Appeal Decisions

Appeal A Ref: APP/R5510/W/20/3254564

21 & 21a Hatherleigh Road (land at rear), Ruislip HA4 6AZ

Appeal B Ref: APP/R5510/W/20/3255436

description
Proposed Plans and Elevations

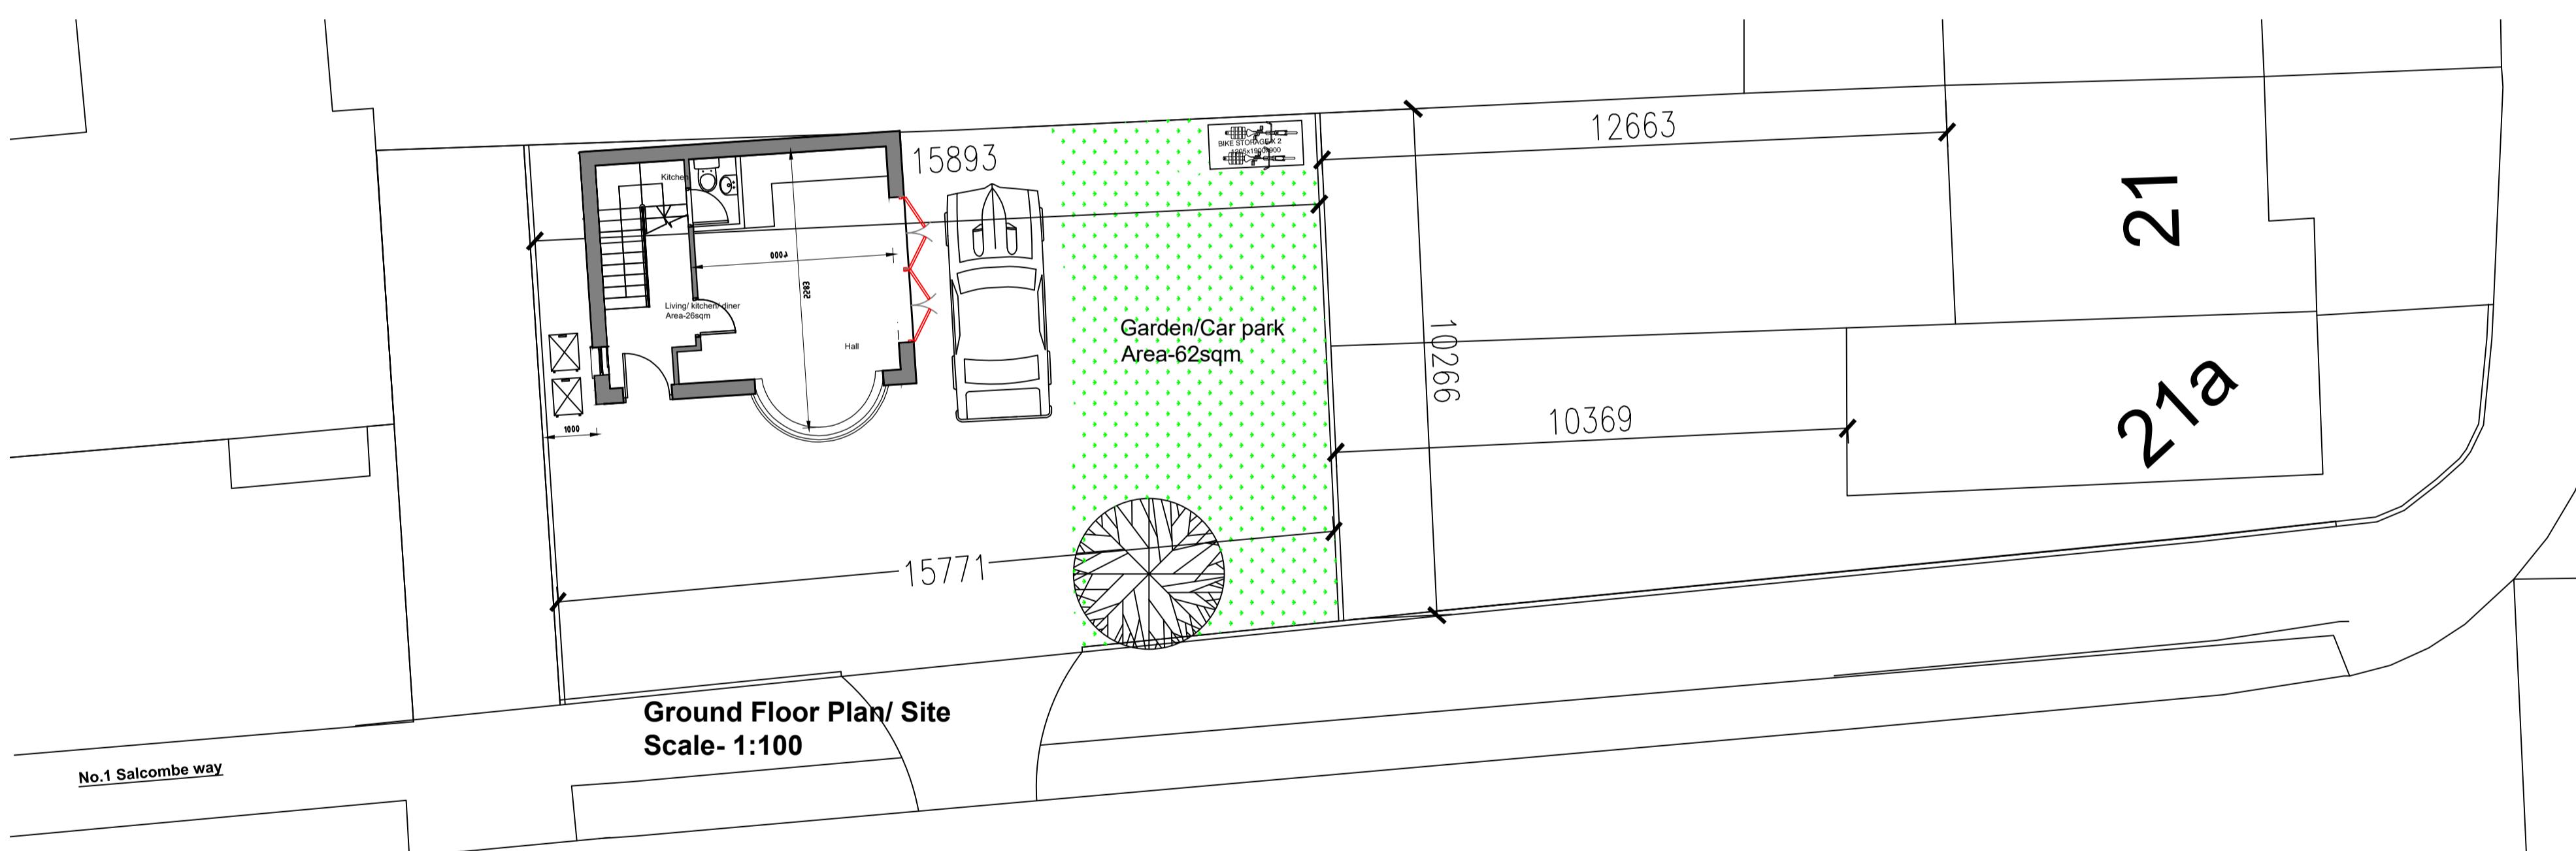
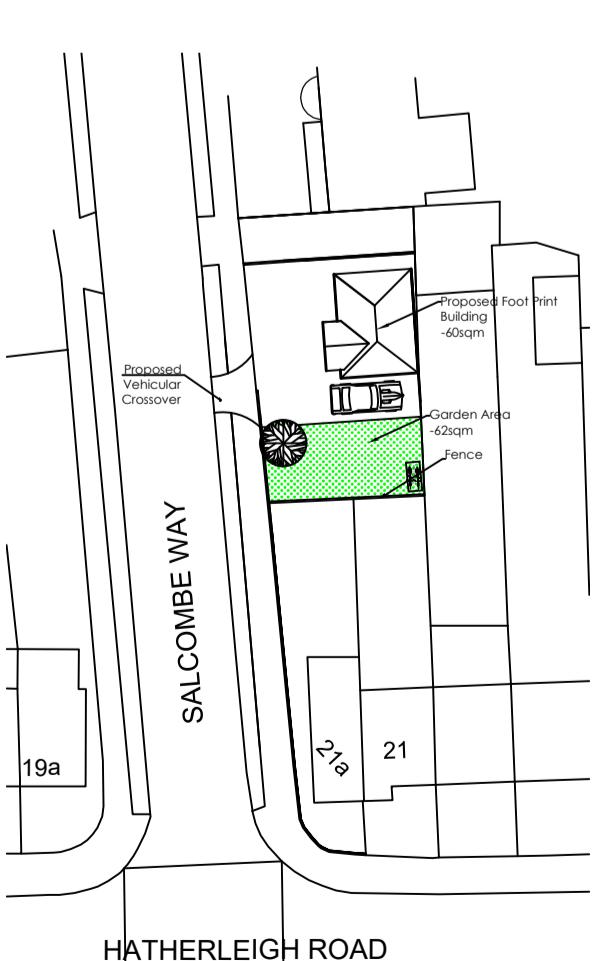
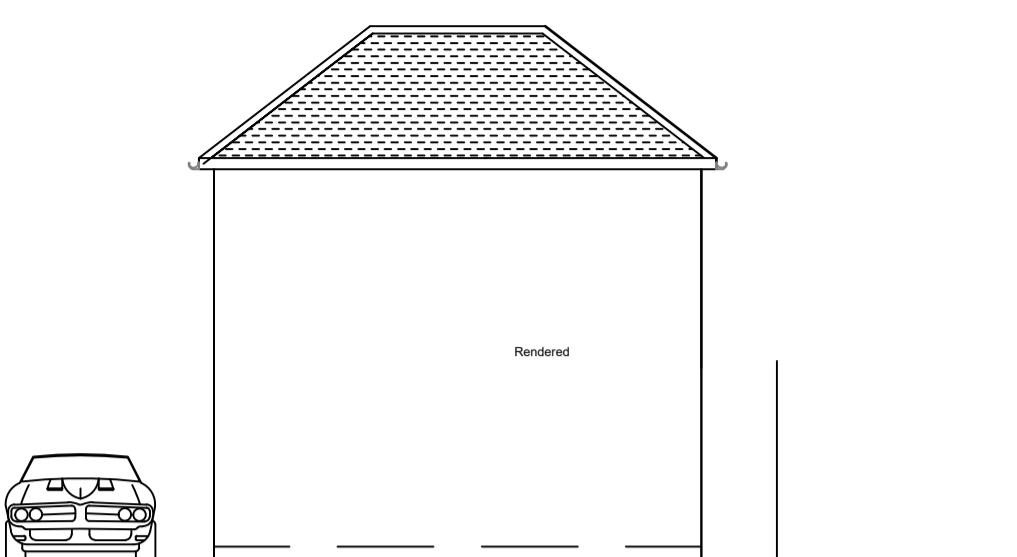
11. The height, scale and finish of the dwelling proposed by Appeal A would be reflective of the character and appearance of the surrounding area however, the positioning of the proposed dwelling would form an uncomfortable juxtapose between the properties on Salcombe Way and the those on

Hatherleigh Road to the north. This is because the front elevation of the dwelling would be set in between the building line set by the gable end of no 21a and that established on Salcombe Way. As a consequence, the Appeal A proposal would fail to accord with character and appearance requirements of Policy BE1 of the Hillingdon Local Plan: Part One- Strategic Policies 2012 (SP) and Policies DMHB 11 and DMHB 12 of the DMP.
